Please ask for: Mrs D Johnson  
Email: [daun.johnson@arun.gov.uk](mailto:daun.johnson@arun.gov.uk)  
Telephone: 01903 737762  
Our Ref: WA/30/20/PL  
Your Ref:  
Date: 7th May 2020

**Application for Planning Permission**

**Development:** Demolition of existing dwelling & erection of 8 No. dwellings with associated landscaping, parking & works. This application is a Departure from the Development Plan.

**Location:** Spindlewood Yapton Lane Walberton BN18 0AS

Drawing.
Proposed Cottage
3 & 4 Plans

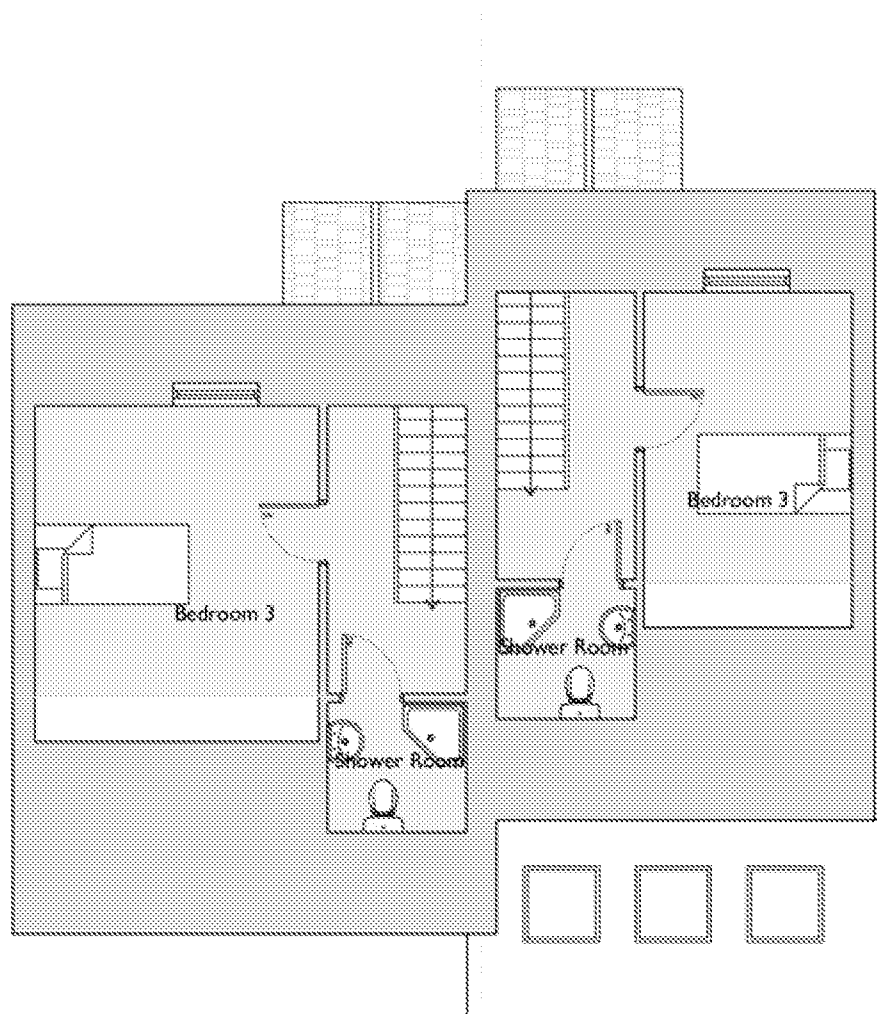
On the proposed block plan, please provide visibility splays.  
The floor plans and elevations do not accord for Cottage 3 & 4. Please amend accordingly.  
Lidsey Foul Water - Environmental Assessment Statement
